October 12, 2017

Re: *Hannah Ridge at Feathergrass Filing No. 4 Final Plat- SF-17-013 - Review 2*
Project No. 60970-F4

M.V.E., Inc. has prepared the following response to comments contained in your October 10, 2017 comment letter concerning the above named project. Revised submittal materials are enclosed as needed. Each comment is addressed below in the order contained in your comment letter.

GRADING AND EROSION CONTROL PLAN

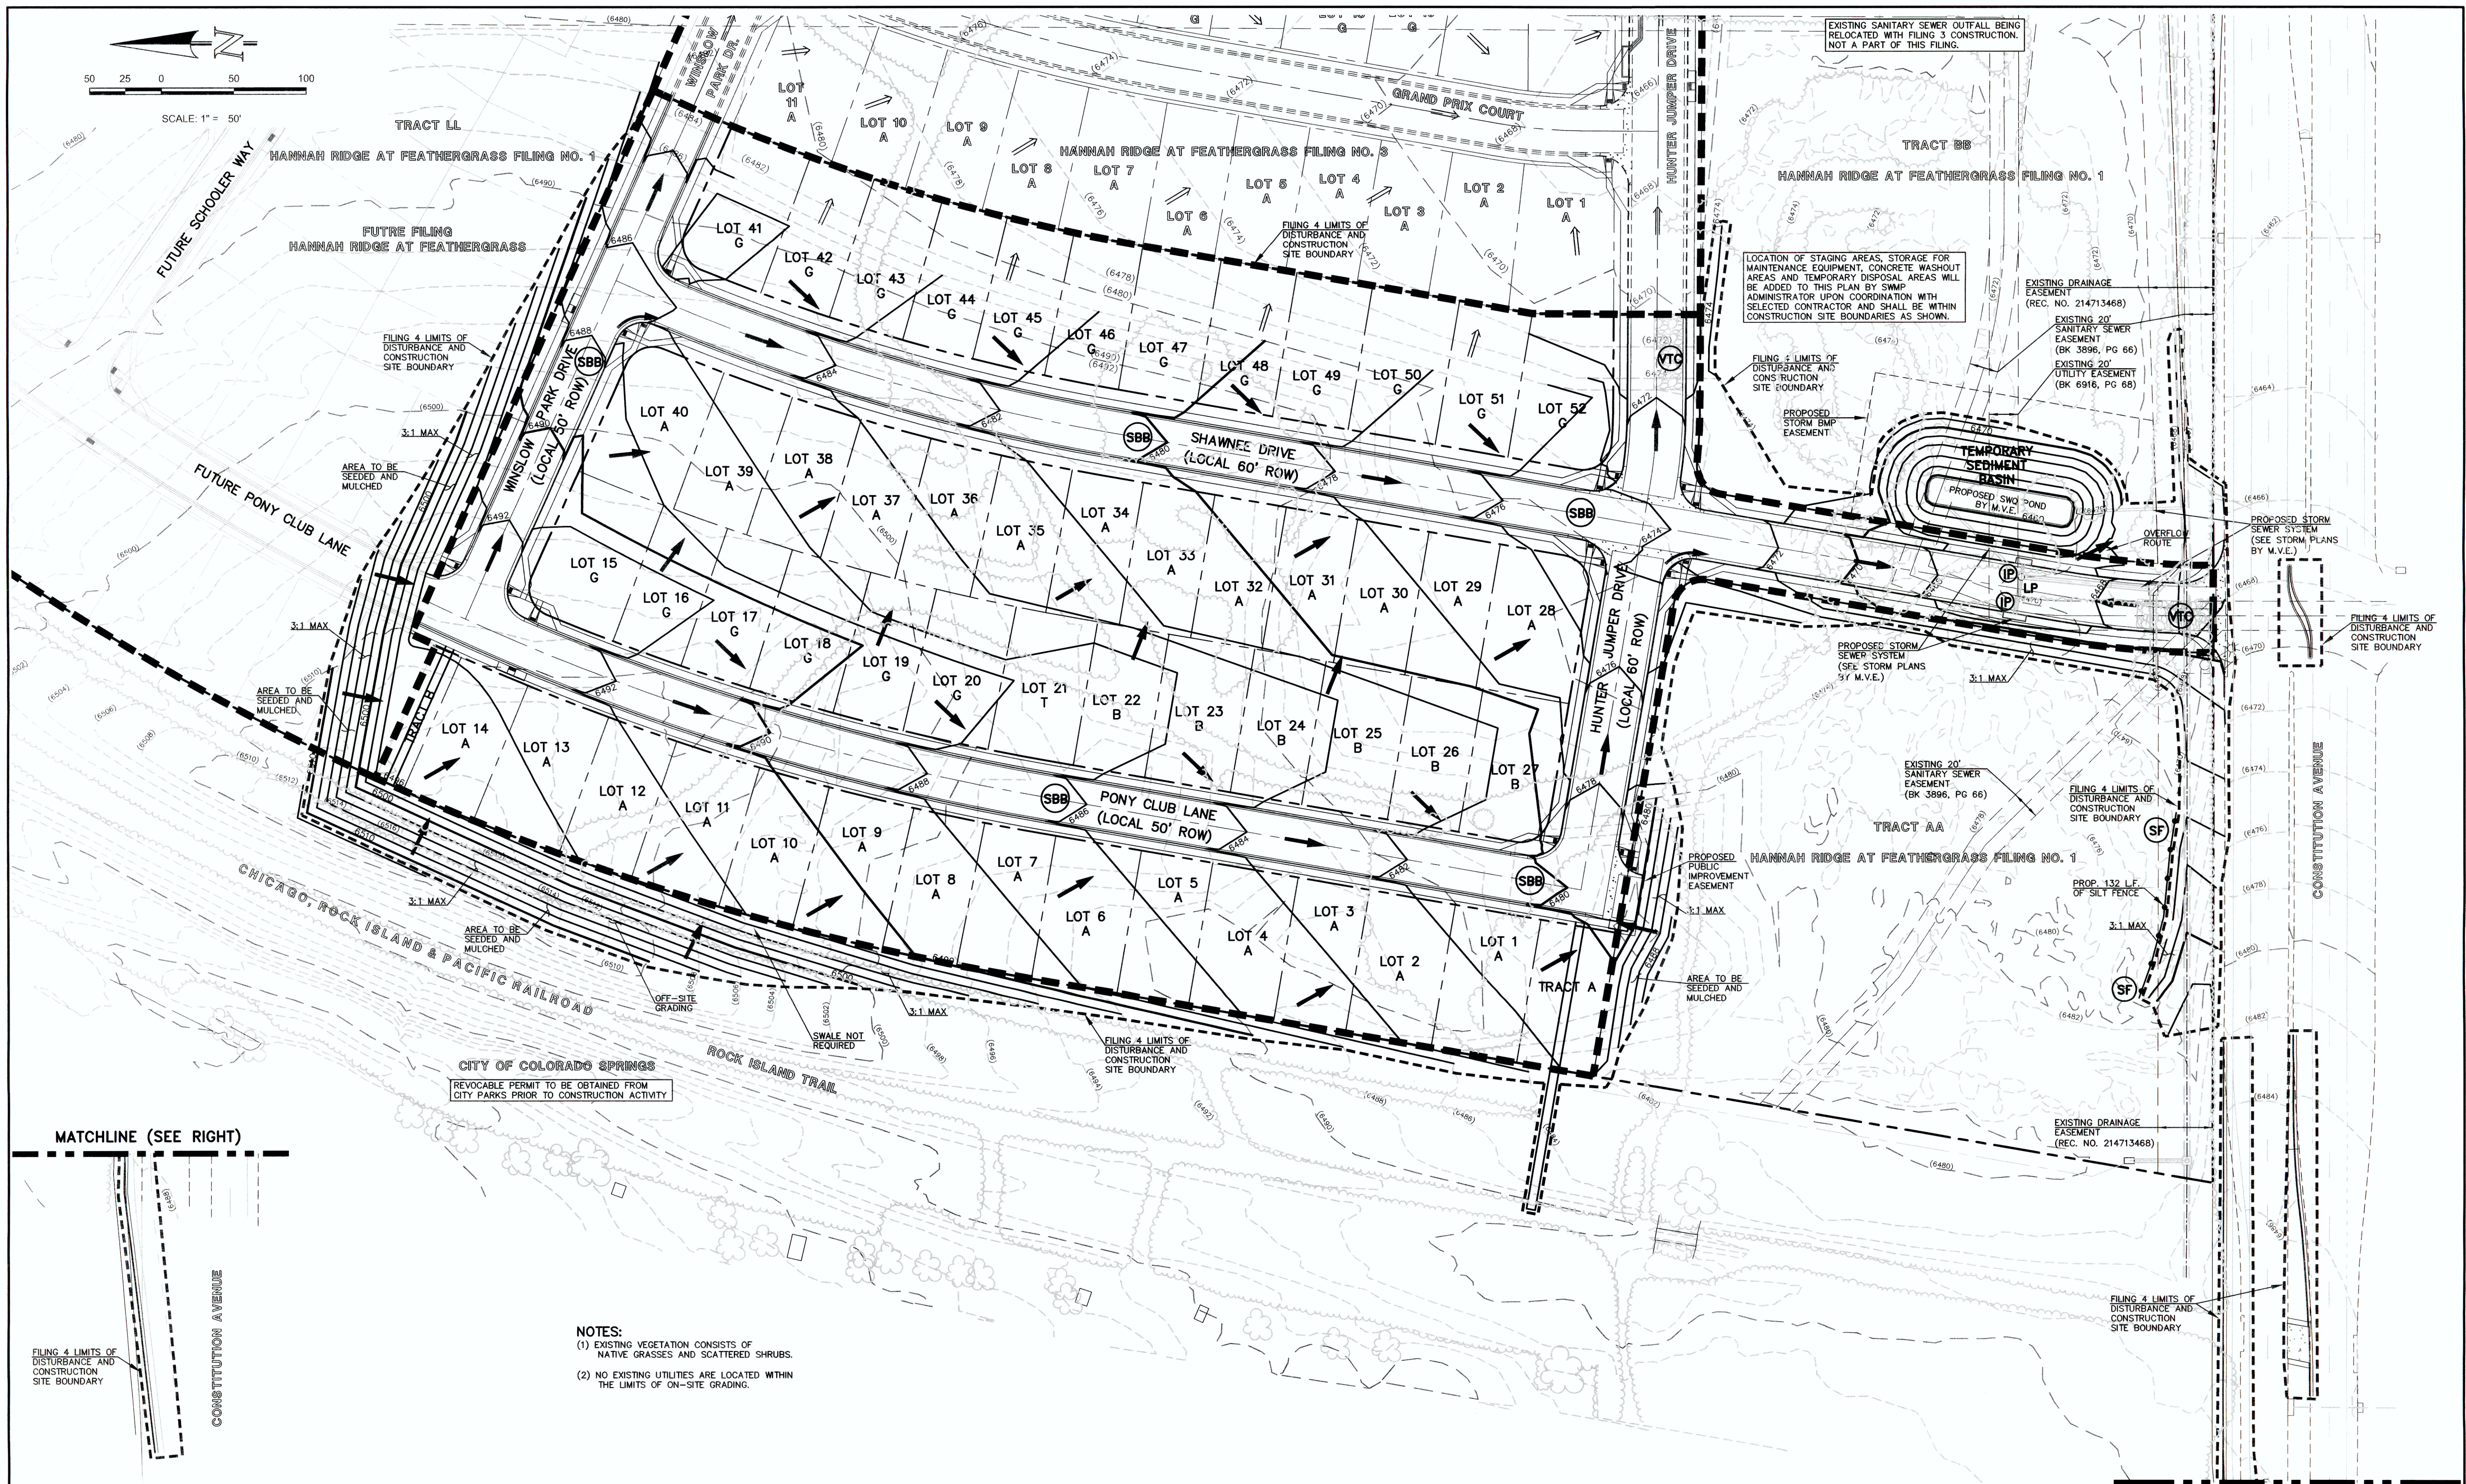
3. *Include all areas to be graded or disturbed with this filing, including storm drainage and utilities to be constructed with Filing 4. Clearly label offsite construction areas. Partially resolved; label the Constitution Ave. median area.* **Response: GEC has been updated.**

FINAL PLAT
Hannah Ridge at Feathergrass
Filing No. 4

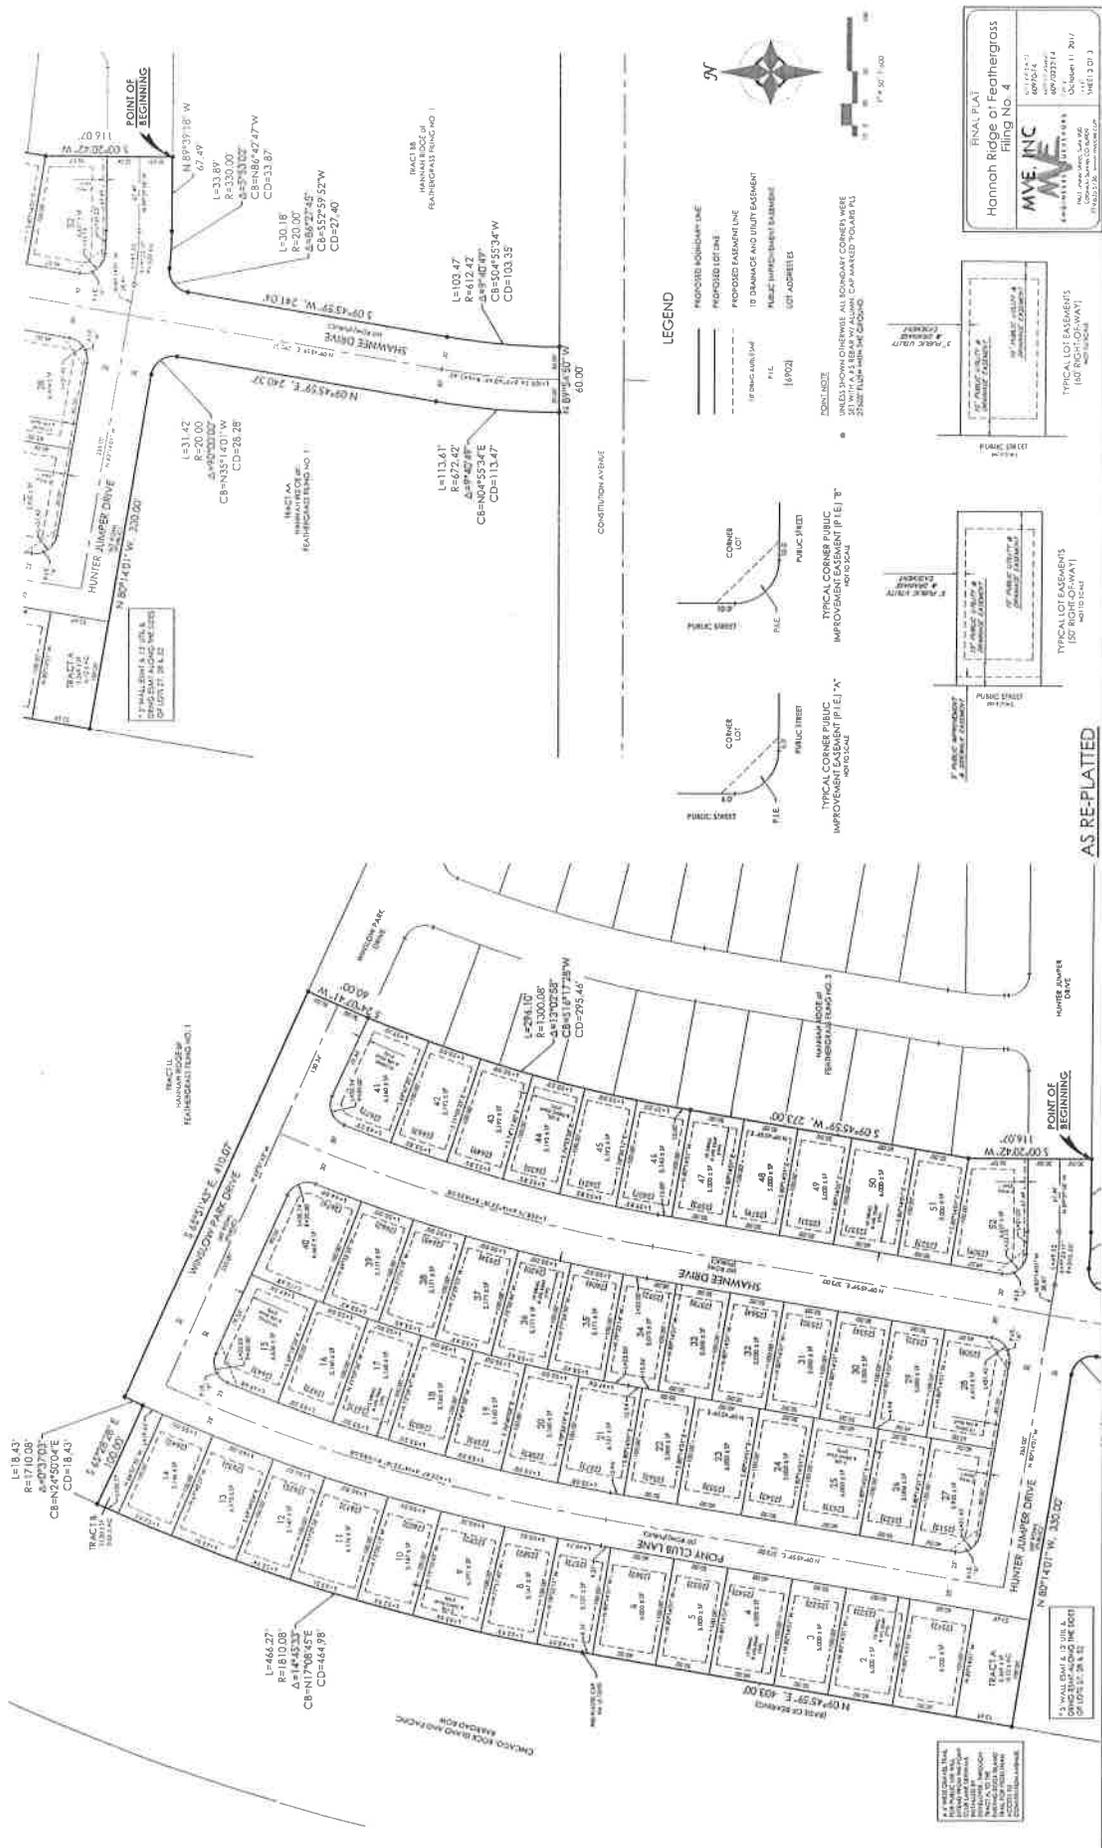
3. See CD comments (redlines) requiring a knuckle at the intersection of Hunter Jumper Drive and Pony Club Lane. If a deviation request is not submitted and approved, revisions to the plat and other documents will be required. Unresolved; if the knuckle won't work, a partial "T" intersection can be utilized. **Response: A partial T intersection has been added to the plans.**
